# Planning Services Sign Permit Review Form

Date of Submittal	Application Number	Applicant	Landowner
06-30-2023	SIGN2306-0006	Wellco Contractors Inc.	Wellco Contractors Inc.

Contact Person	Contact Number
Jason Wellons	910-263-0276
Sign Location	PIN #
NW Corner of Poplar Drive & Docs Rd.	0506-34-8997.000

**PLOT PLAN**

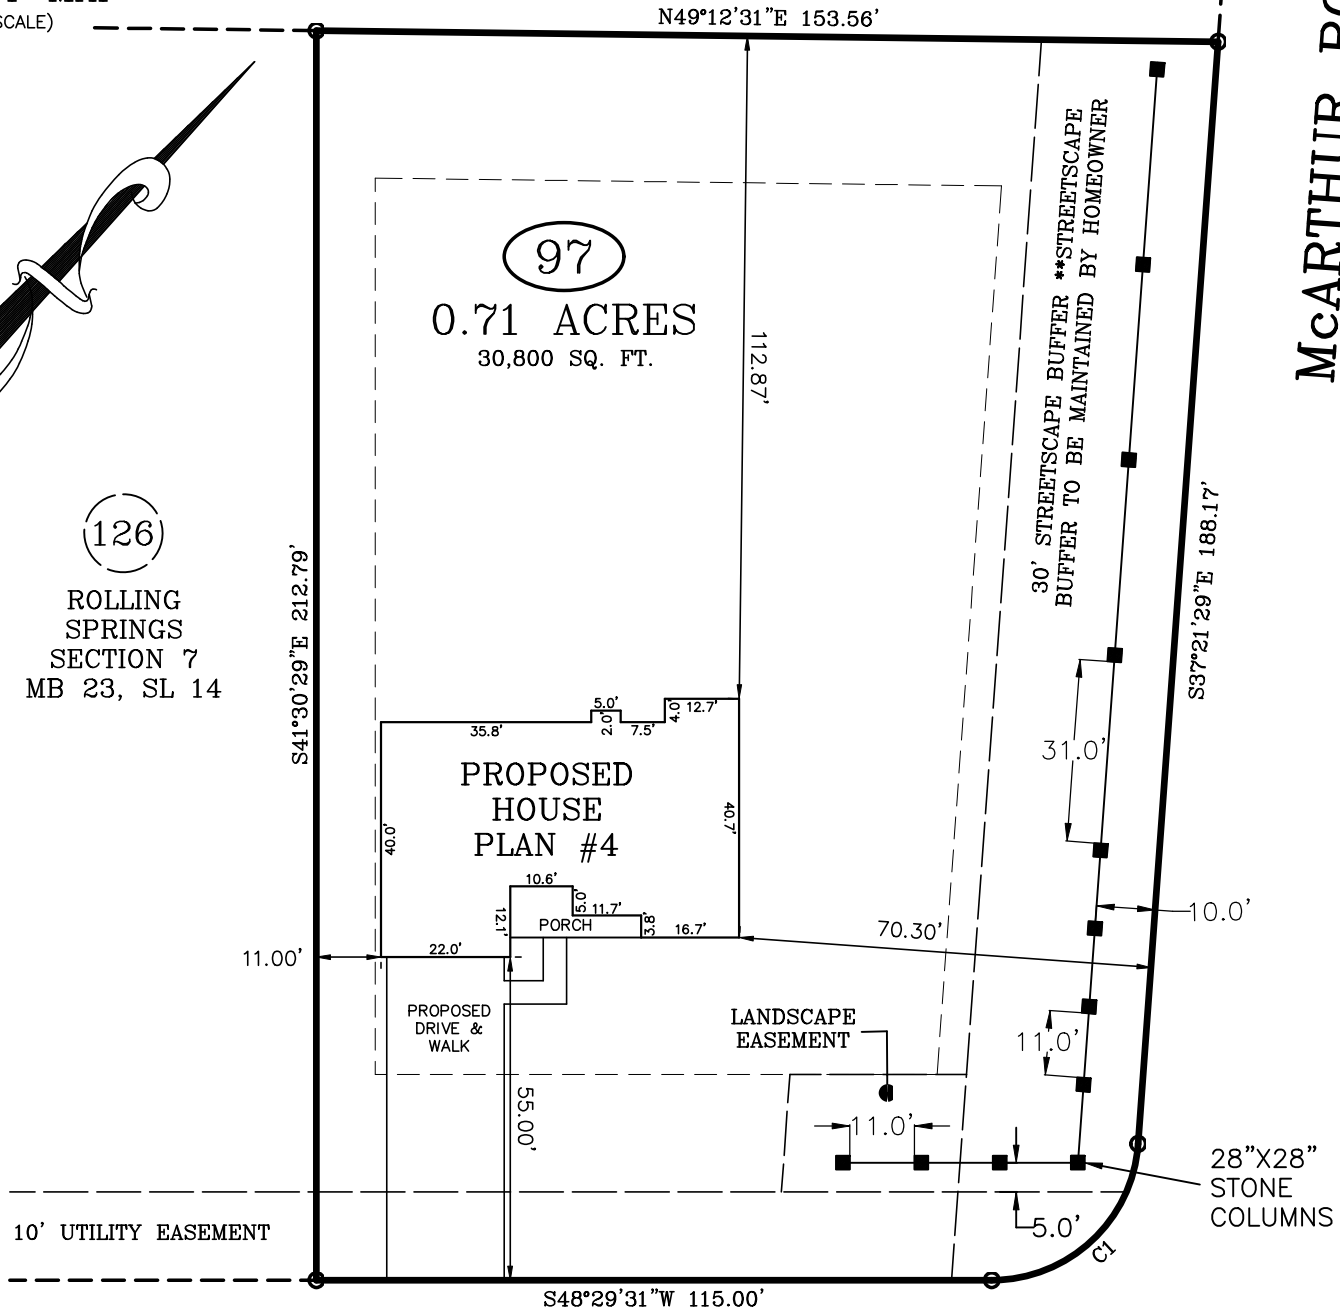
<b>Comments</b>	<ol style="list-style-type: none"> <li>1. Please provide the distance between the proposed sign location and the edge of ROW (Poplar Dr. and Docs Rd.).</li> <li>2. The fencing cannot be apart of the sign. Please revise the plans to show that the sign and the fence in the landscaping buffer will remain two separate features.</li> </ol>
-----------------	--
